Re: Building "N" Delaware Ct.

I have completed the review and have the following questions/comments?

**FOOTING DETAIL**  
 SCALE: 3/4"=1'-0"  
 NOTE:  
 SUBSTITUTE FOOTING AND WALL SIZES WITH PLAN CALL-OUT.

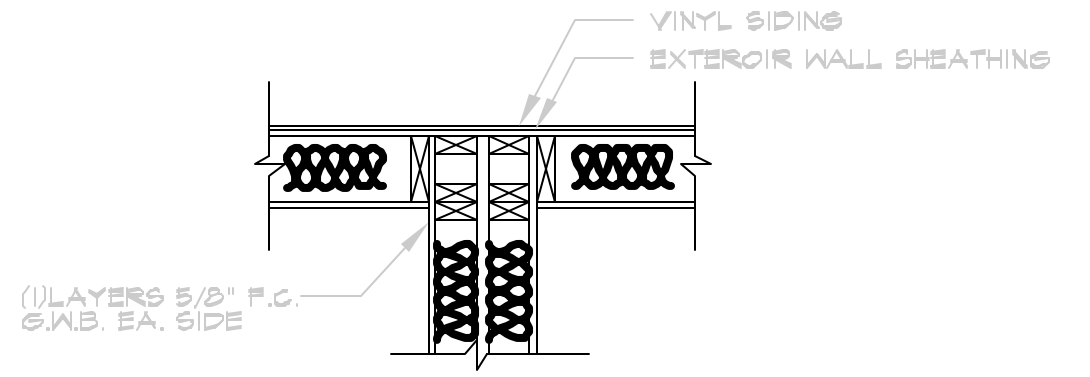
- 1)The thickness of the footings appears to scale at less than 8"(detail 1/A2)
- 2)Crawl space ventilation is not shown.
- 3)What is the spacing of the anchor bolts?
- 4)What type of door is being used from the garage living space.
- 5)Safety Glazing for the windows in the interior stairways may be required (need more detail)
- 6)Attic Access is not shown.
- 7)Treads and risers on exterior stairs not shown
- 8) If there are two 7 3/4 inch risers going to the main entry, guards are required.
